From: Jasmine Kaur Singh [REDACTED]
Sent: 24 July 2021 22:57 [REDACTED]
To: Daniel Vick <Daniel.Vick@arun.gov.uk>
Subject: FW: LU/134/21/PL & LU/135/21/L The Farm, East Street, Littlehampton

Subject: LU/134/21/PL & LU/135/21/L The Farm, East Street, Littlehampton

Block Plan
1:500

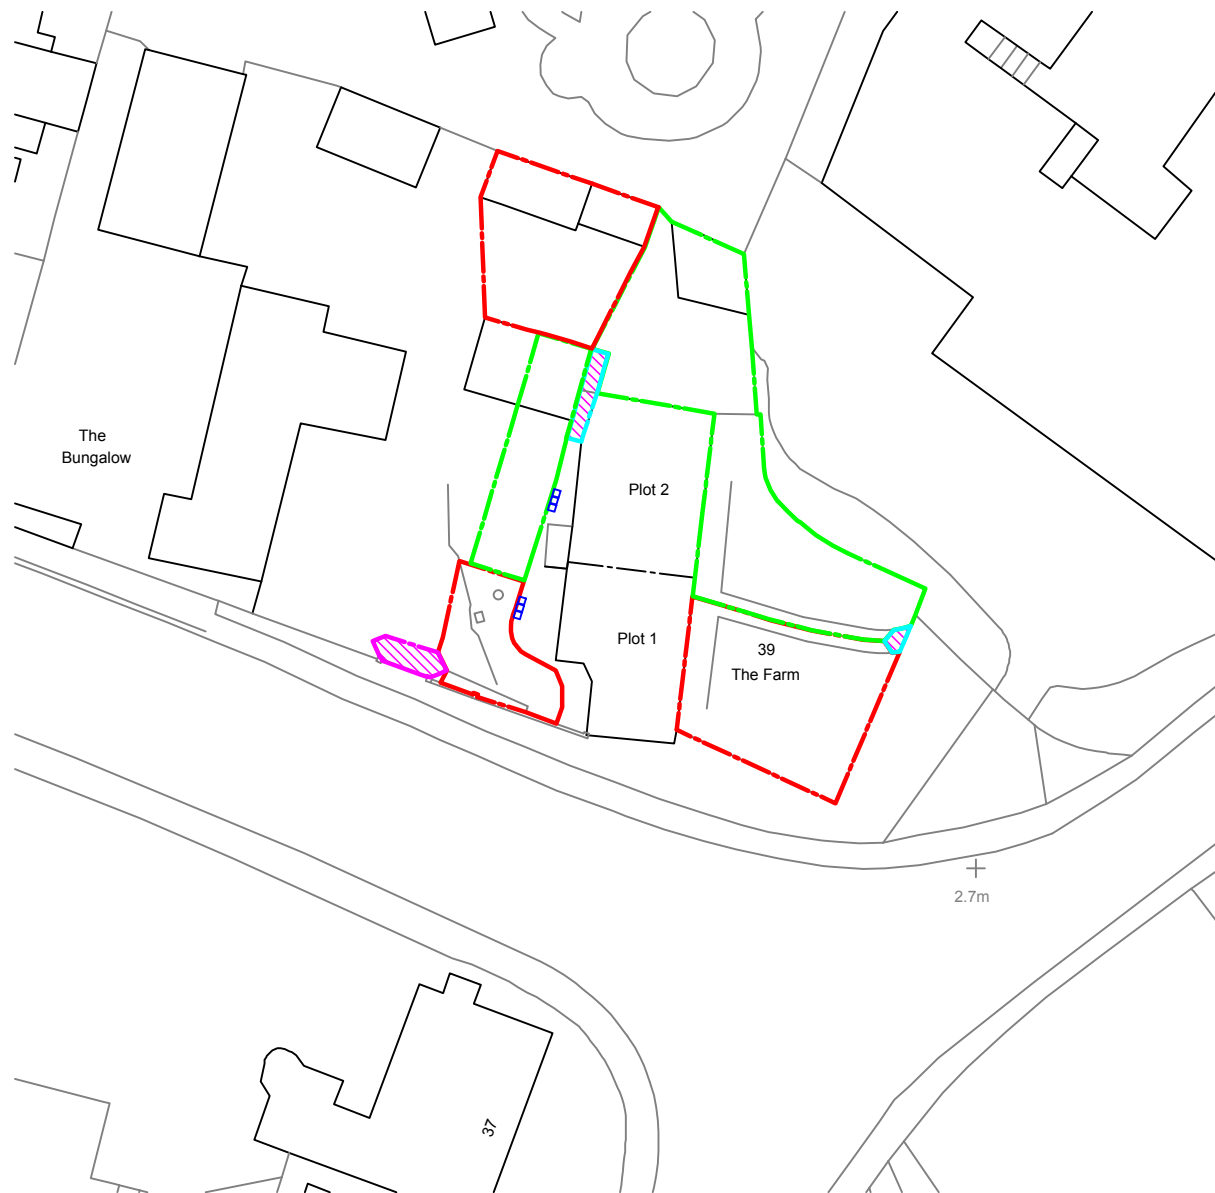
Also if you could confirm about the parking facilities on site ?

Please find attached a document which I trust addresses your query over the proposed parking arrangements.
